**Our Ref: AW/331/13/
Your Ref:**

Application for Planning Permission for Works or Extension to a Dwelling

Development Extensions, structural alterations, balcony & carport

Location 3 Shorecroft Bognor Regis West Sussex

North Elevation

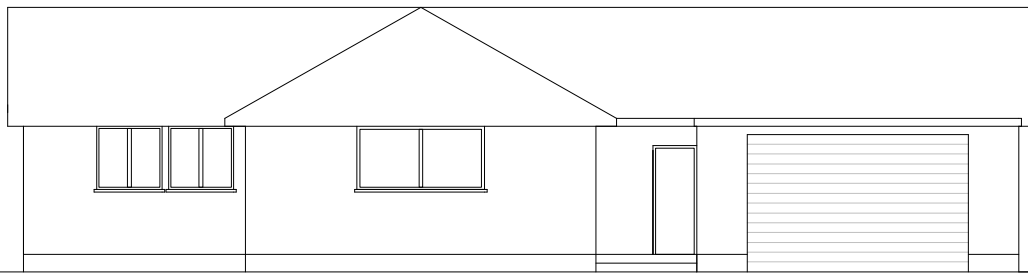
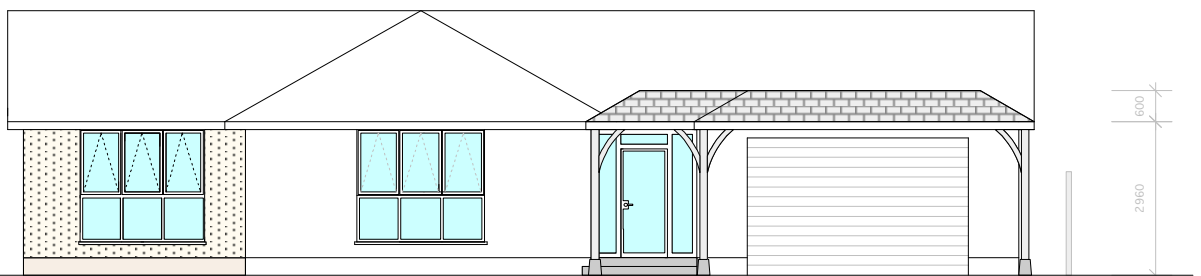
The proposed north elevation is missing the cloakroom window. Please revise
